RE: ST FRANCIS COLLEGE STAGE 1 - LANDSCAPING (SSD-10365)

City Plan Strategy & Development P/L (City Plan) acts on behalf of the proponent of the abovementioned application. This correspondence responds to the NSW Department of Planning, Industry & Environment's (DPIE) request for additional information in relation to the abovementioned application, dated 11 August 2020. DPIE's request also sought a response to submissions received from the public as well as other government agencies during the application's exhibition period.

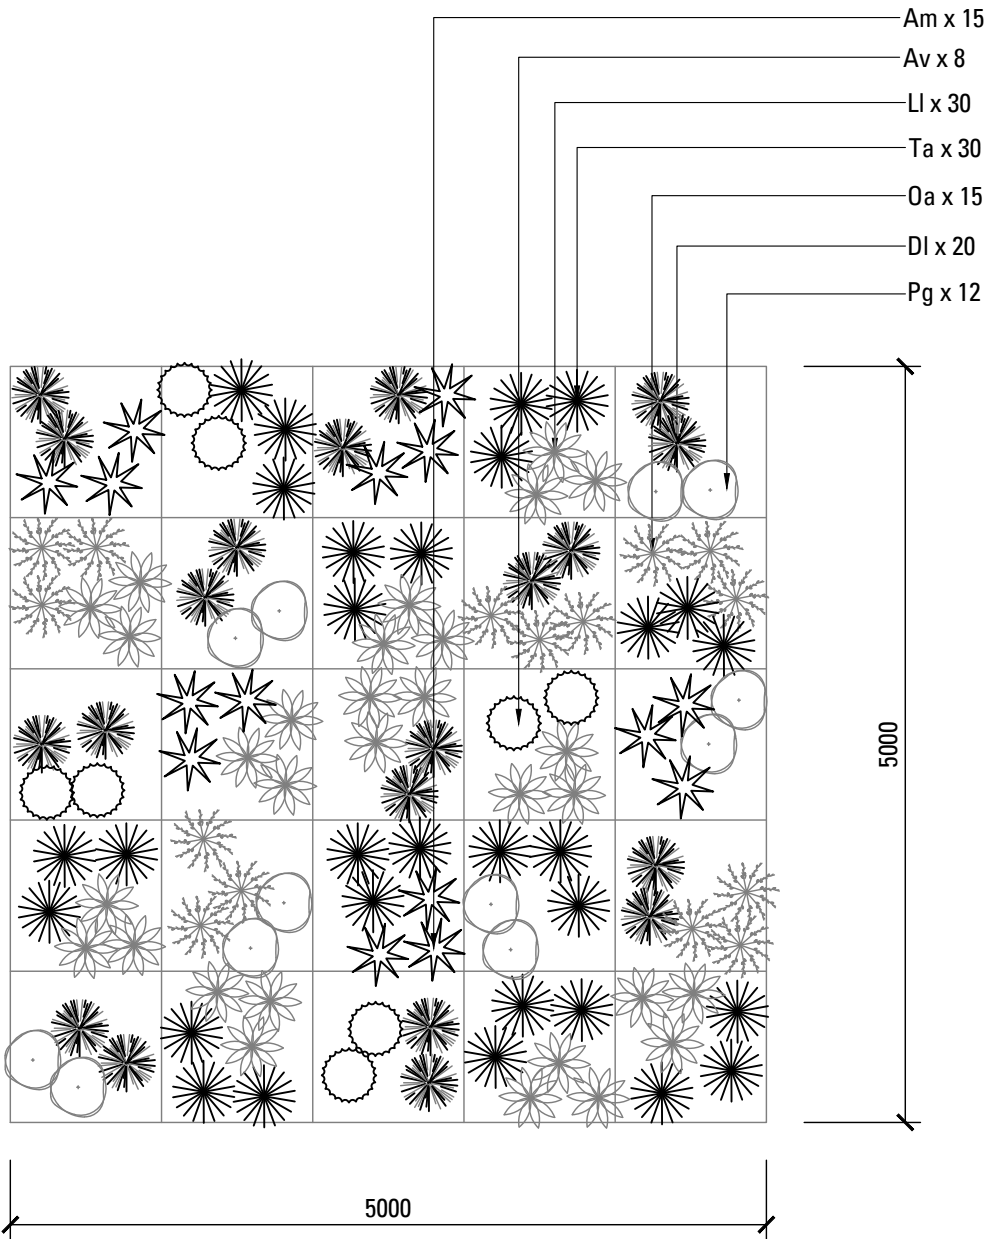
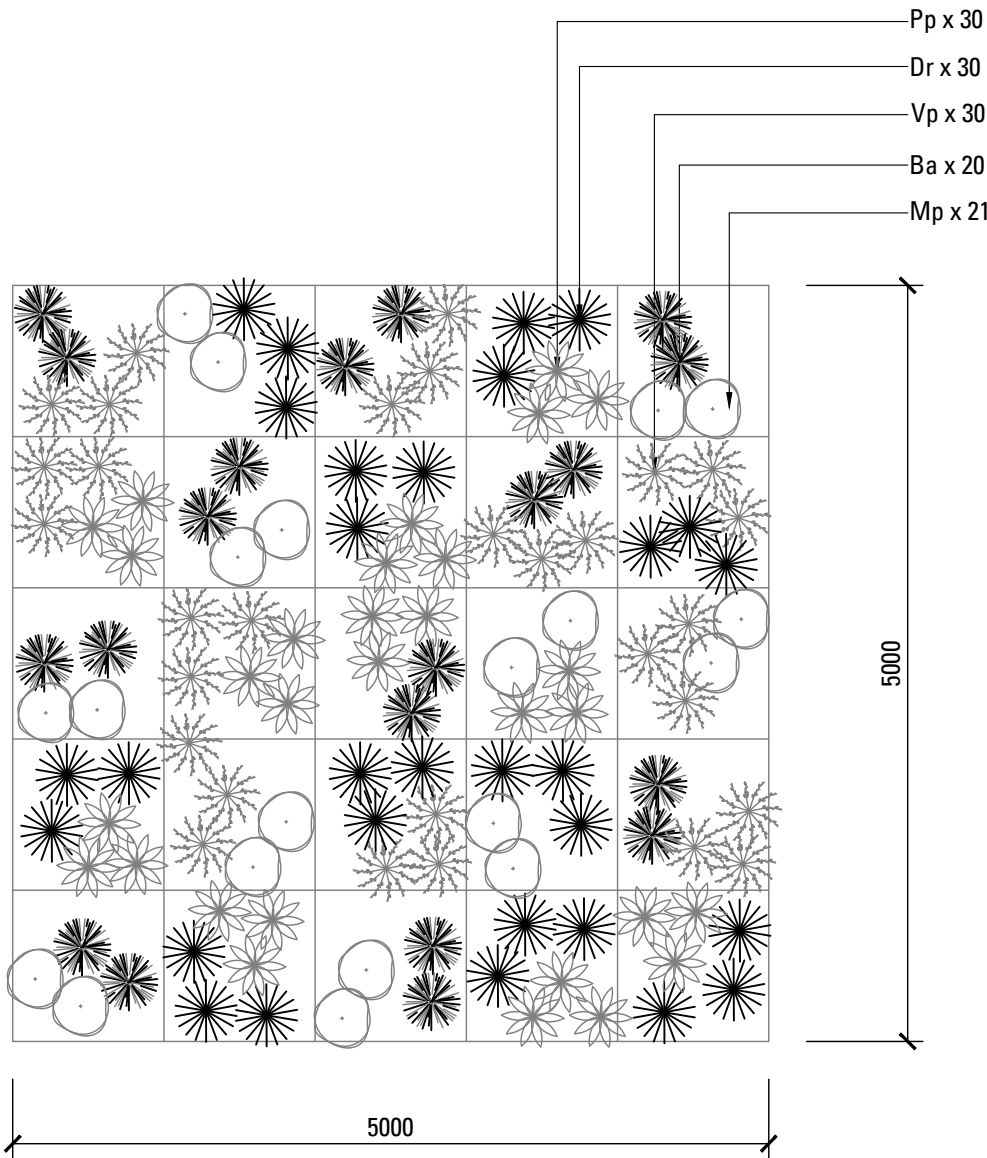
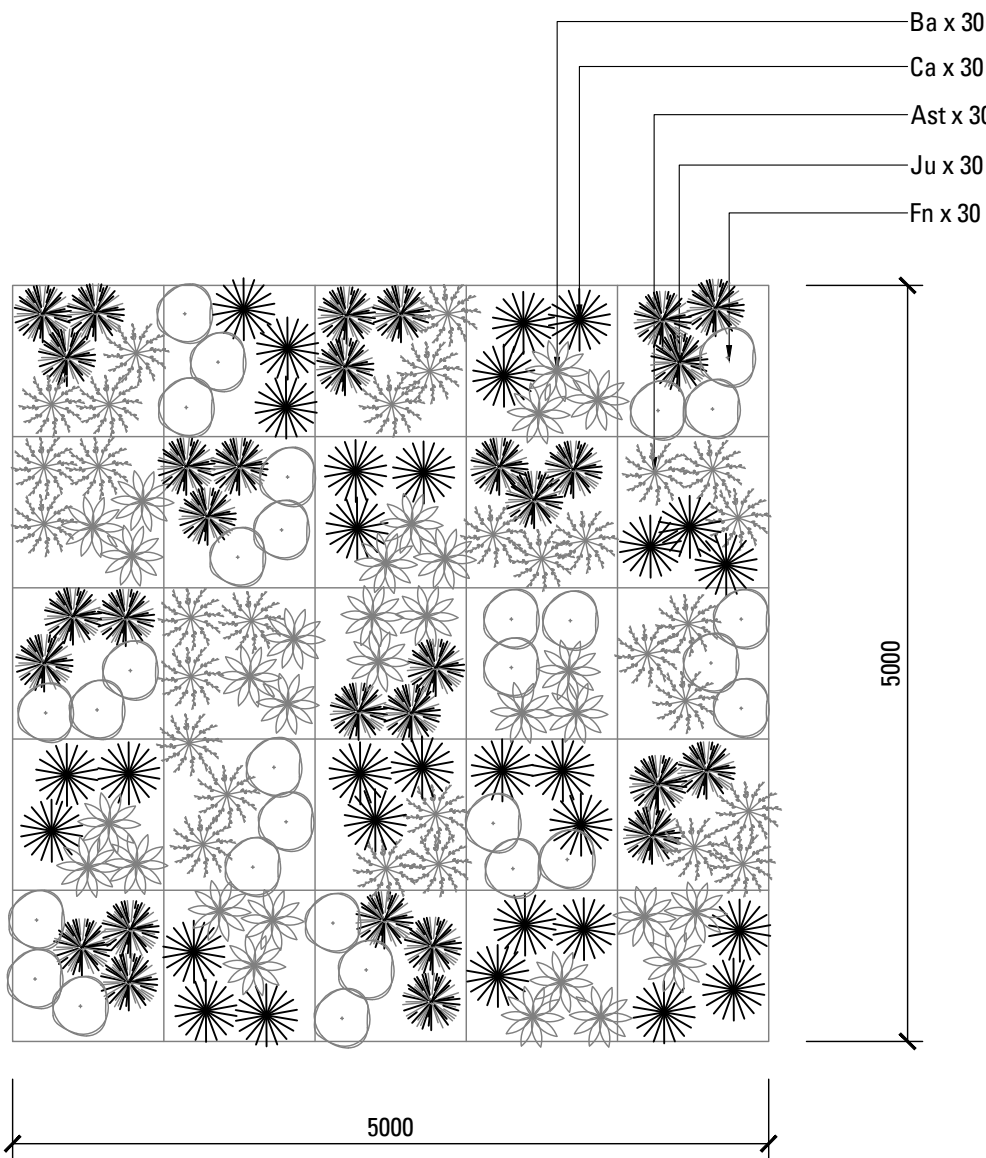
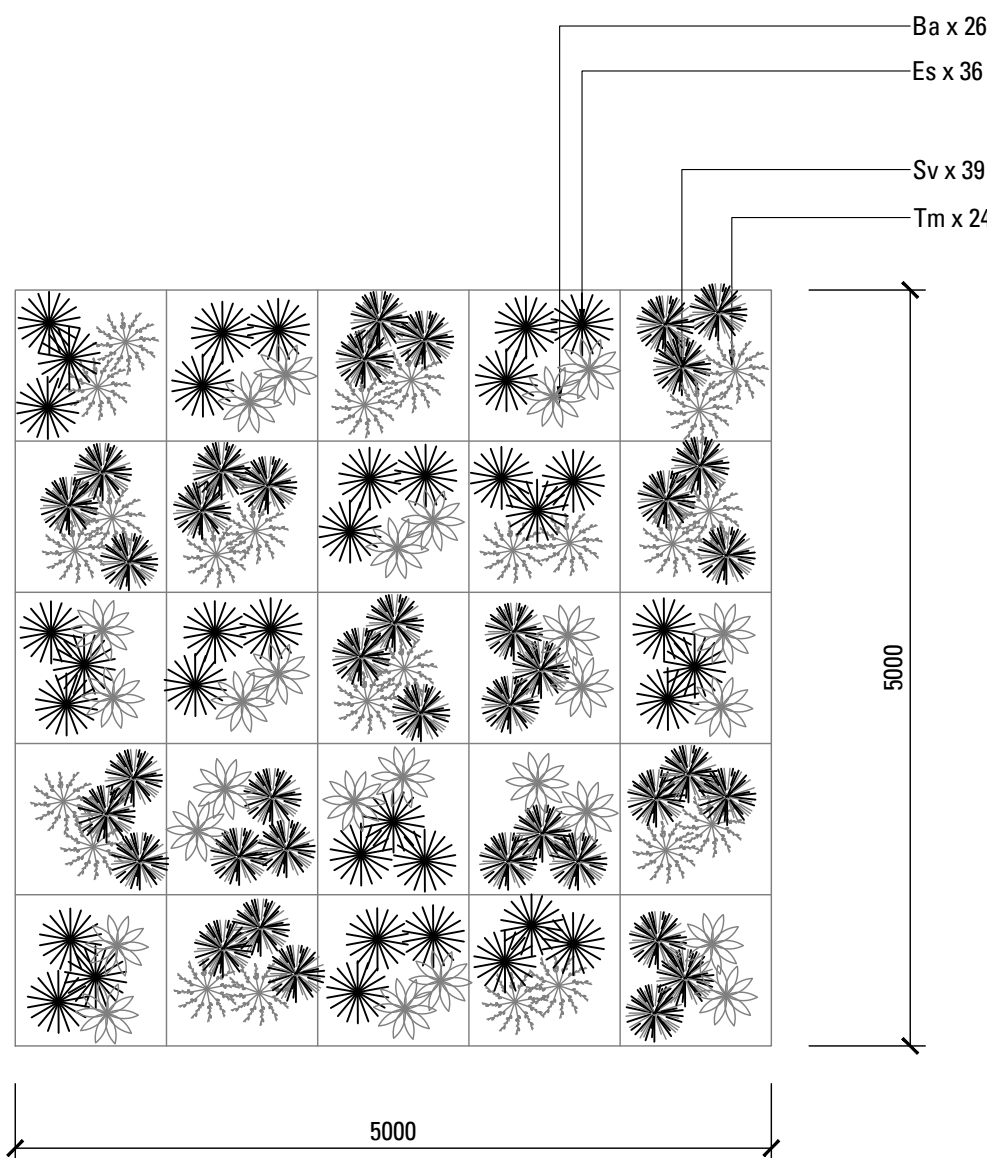
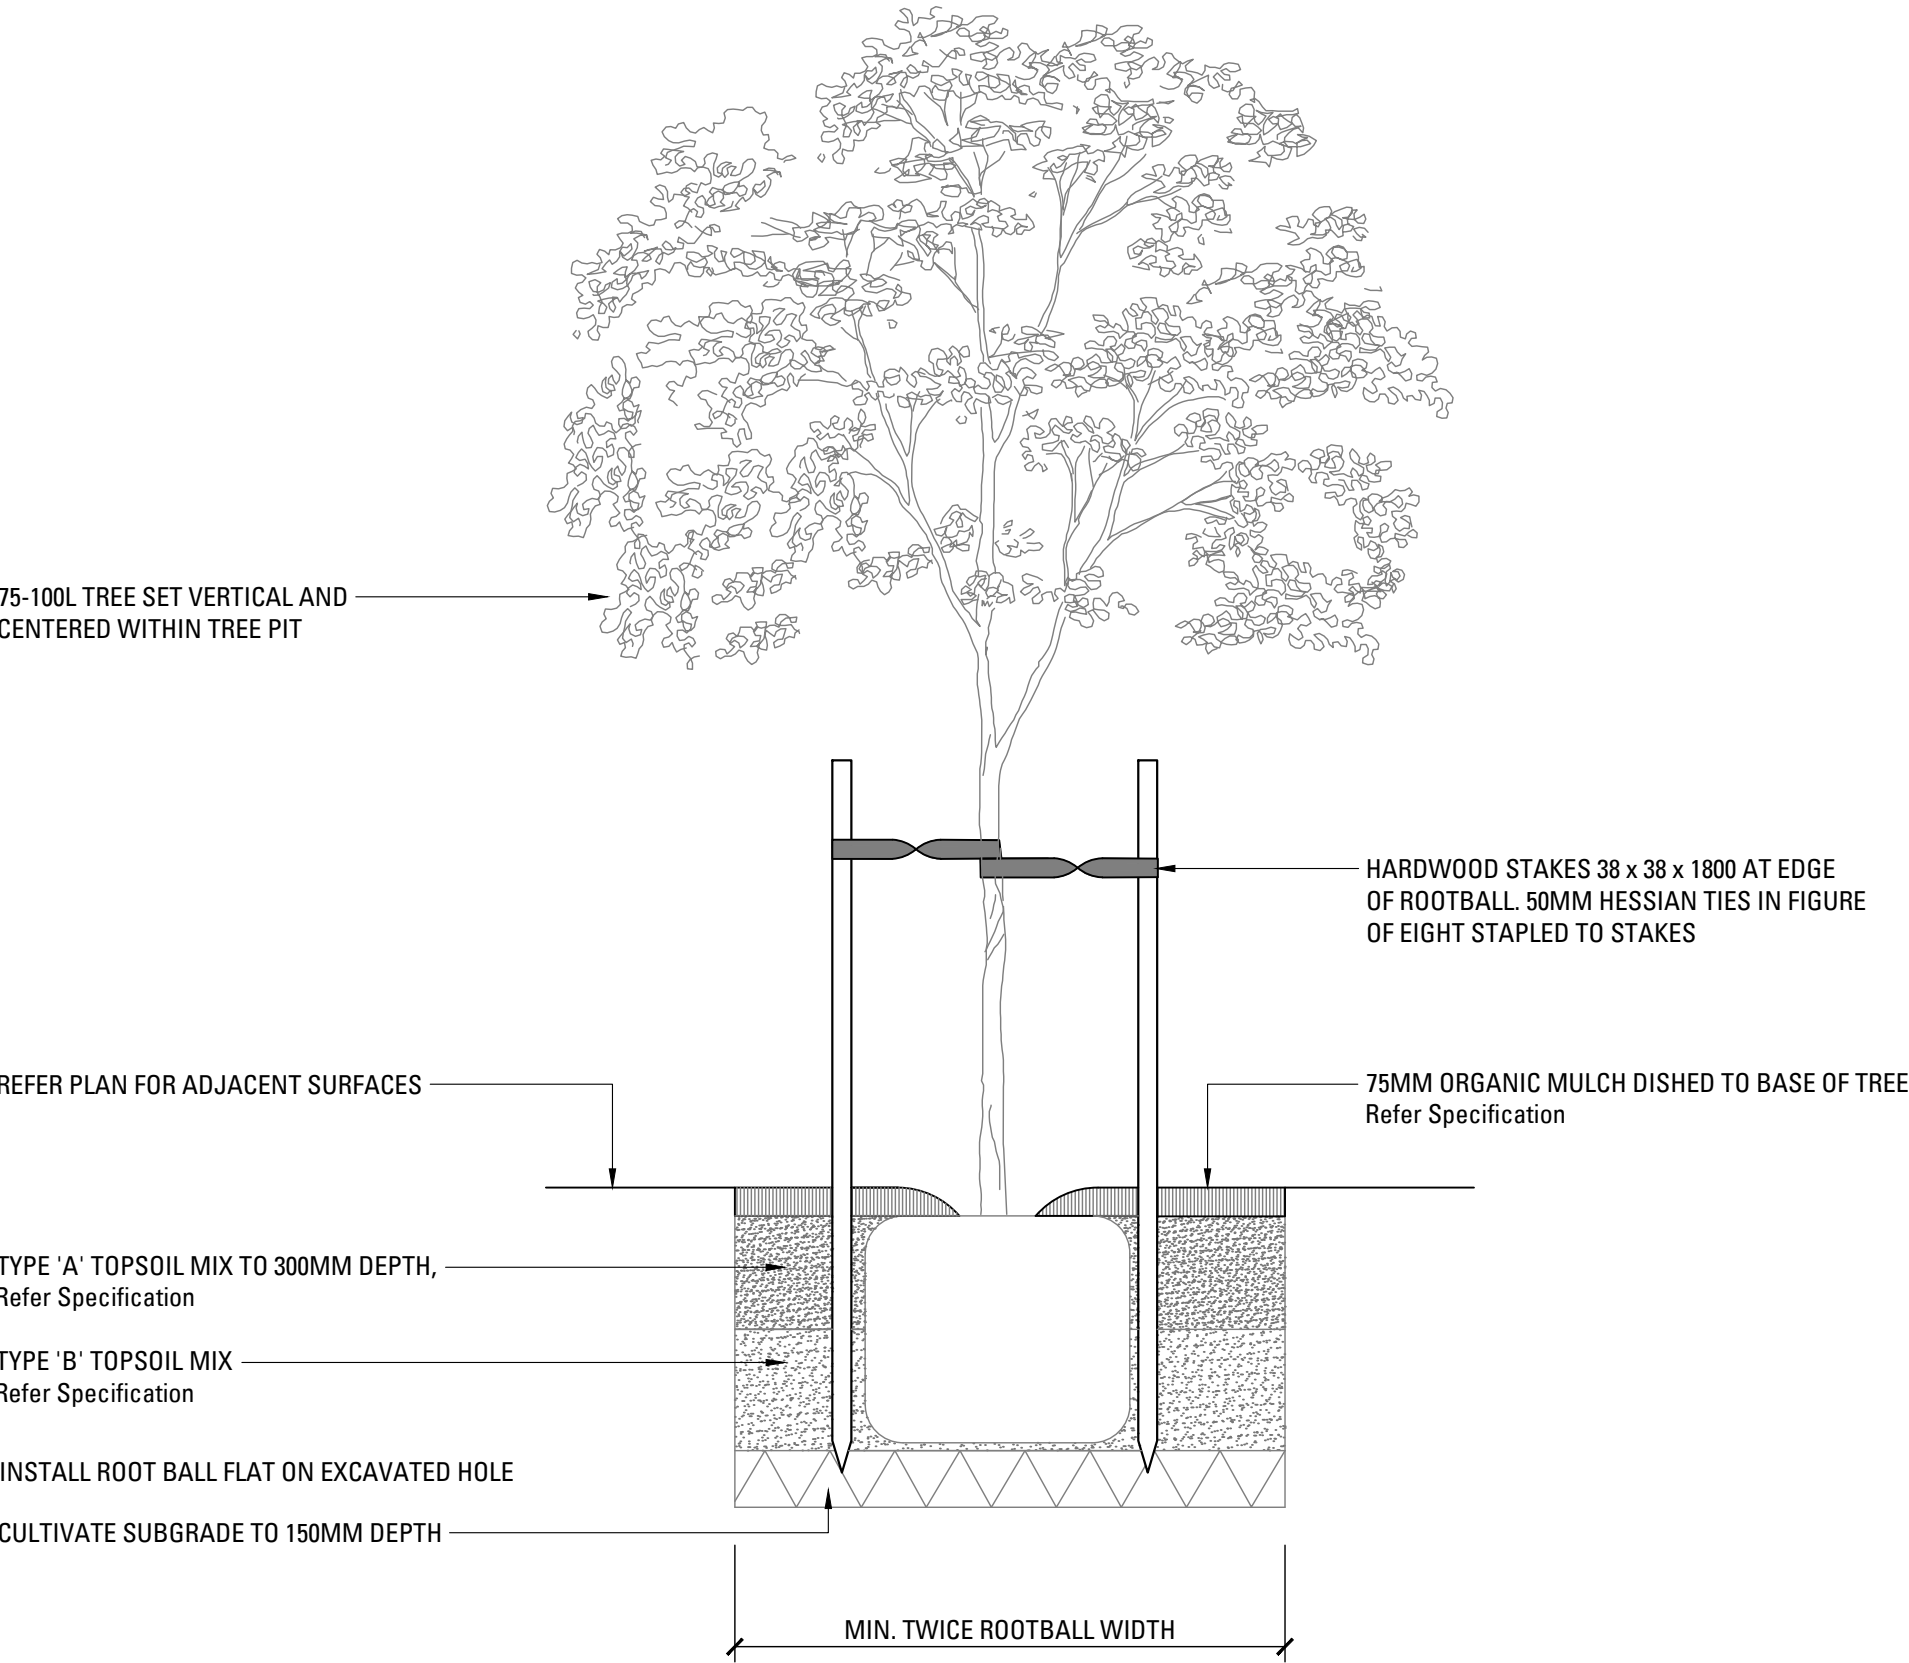
The EESG stated that the proposed planting schedule included several species which did not reflect, as required by the SEARs, vegetation communities native to the subject locality. The EESG is correct in this regard. However, the vast majority of species within the proposed planting schedule do reflect the subject vegetation community. The number of proposed species which are not is, in fact, quite minor. As a result, it is our view that the proposed planting schedule is consistent with the SEARs.

As DPIE will realise, the original condition of the subject locality is highly modified. Species which may not be derived from the locality's original community were selected as these will adapt to the highly modified environment and assist with the establishment of the entire landscape concept.
